## PLANNING CONSULTATION RESPONSE

<b>Application No</b>	2025/0849
<b>Proposal</b>	Redevelopment of builder's yard to erect two dwellings
<b>Address</b>	Birkland Farm, Fullshaw Lane, Langsett, Sheffield, S36 9FD
<b>Date of Consultation Reply</b>	10/11/2025
<b>Consultee</b>	Highways Development Control

Thank you for consulting Highways Development Control on this application for the redevelopment of a builders yard to residential in the form of 2 dwellings.

01 Block Plan  
1:500

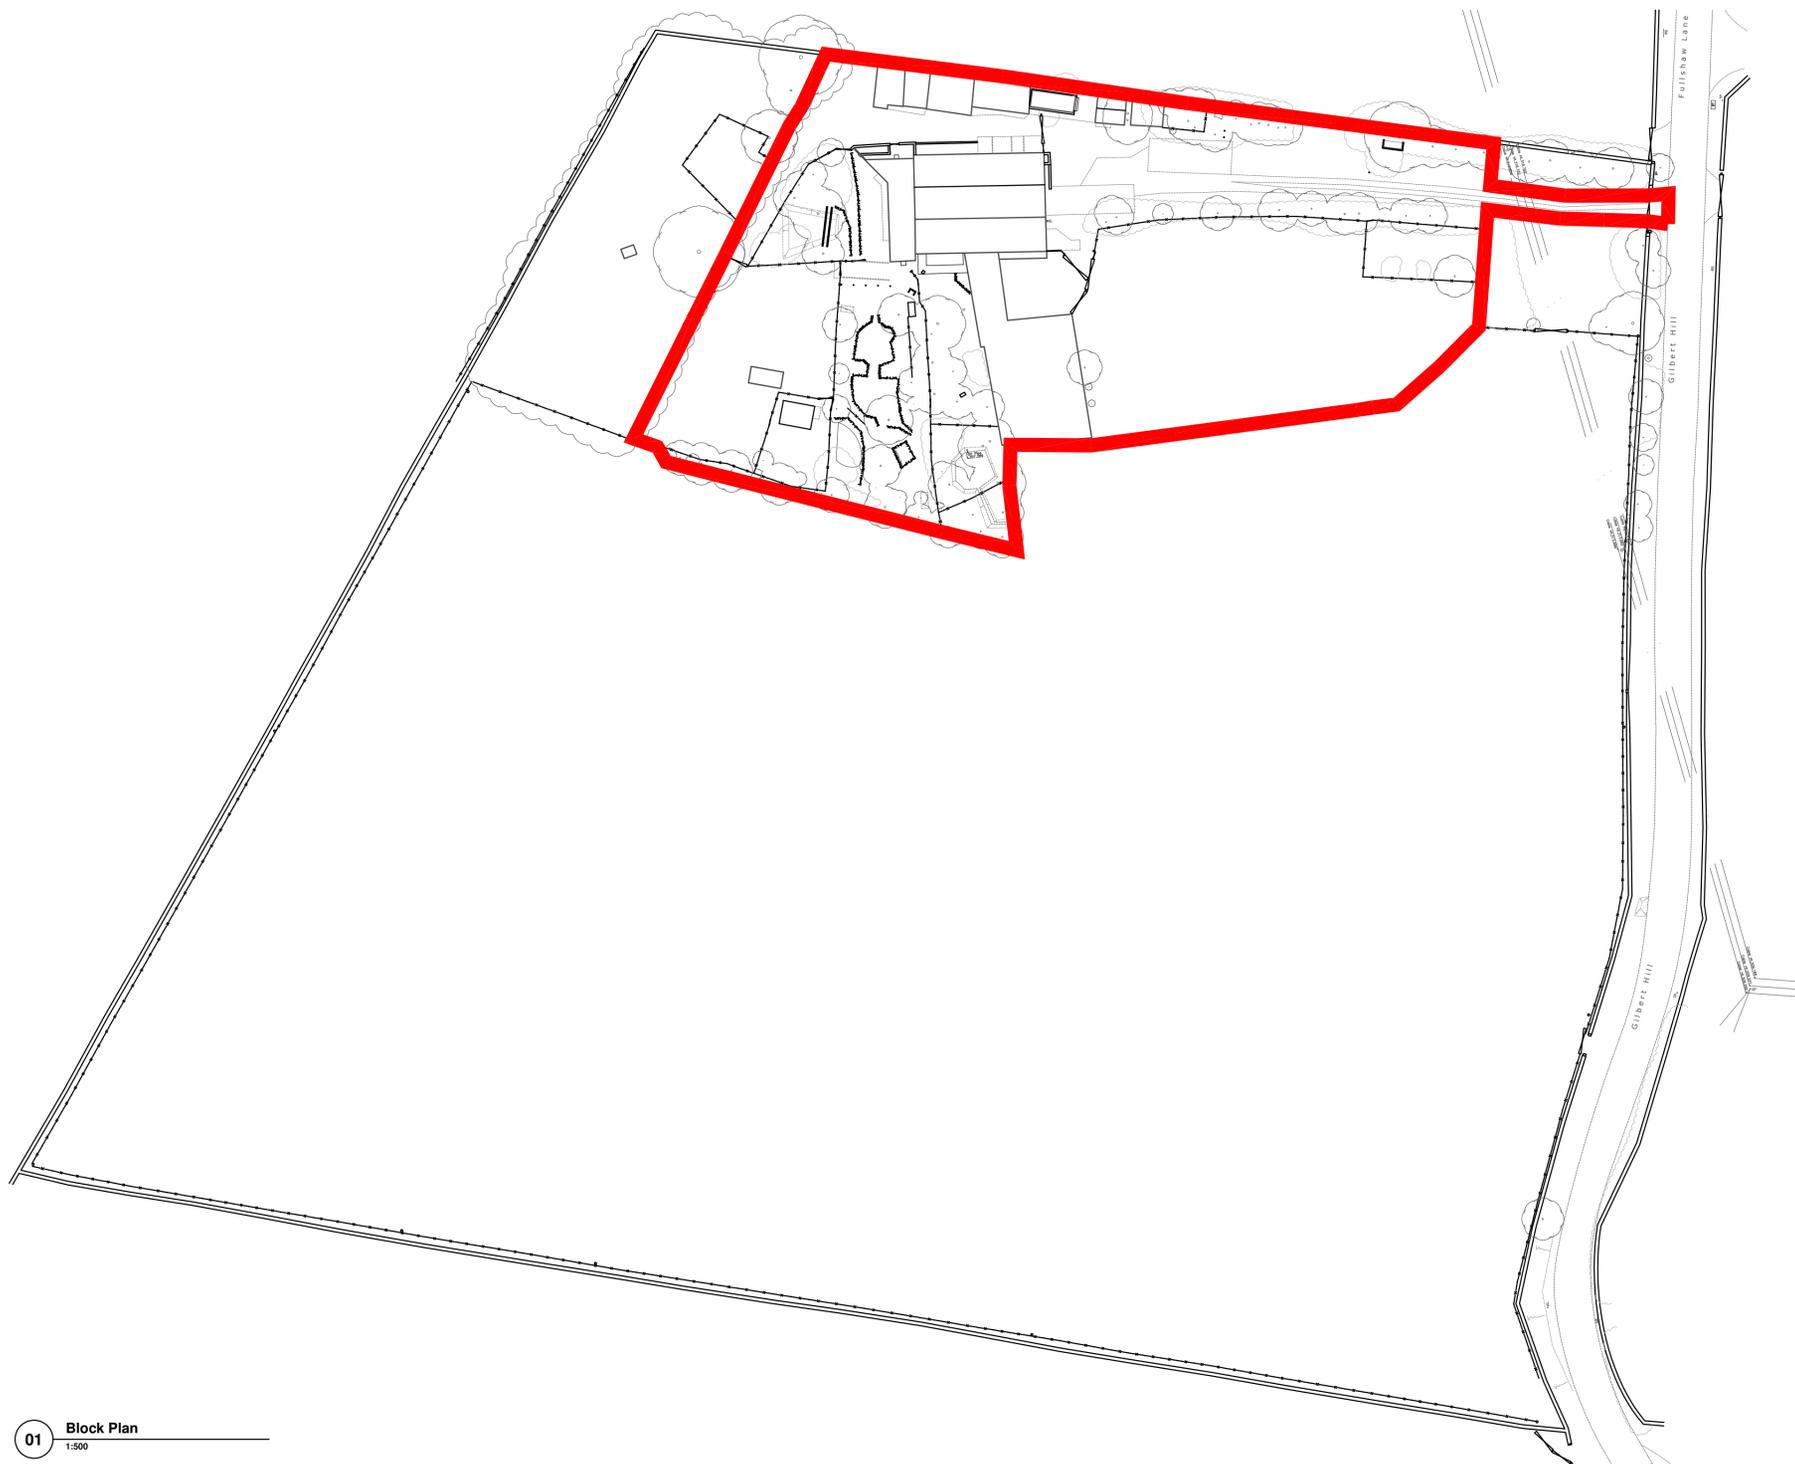
Notwithstanding the above, I note from relatively recent street images, that the access appears to be bound by overgrown vegetation which will restrict visibility from the access. Minimum visibility splays for a derestricted road of 4.5m x 215m should be demonstrated on a site plan with all vegetation cut back and maintained as such thereafter.
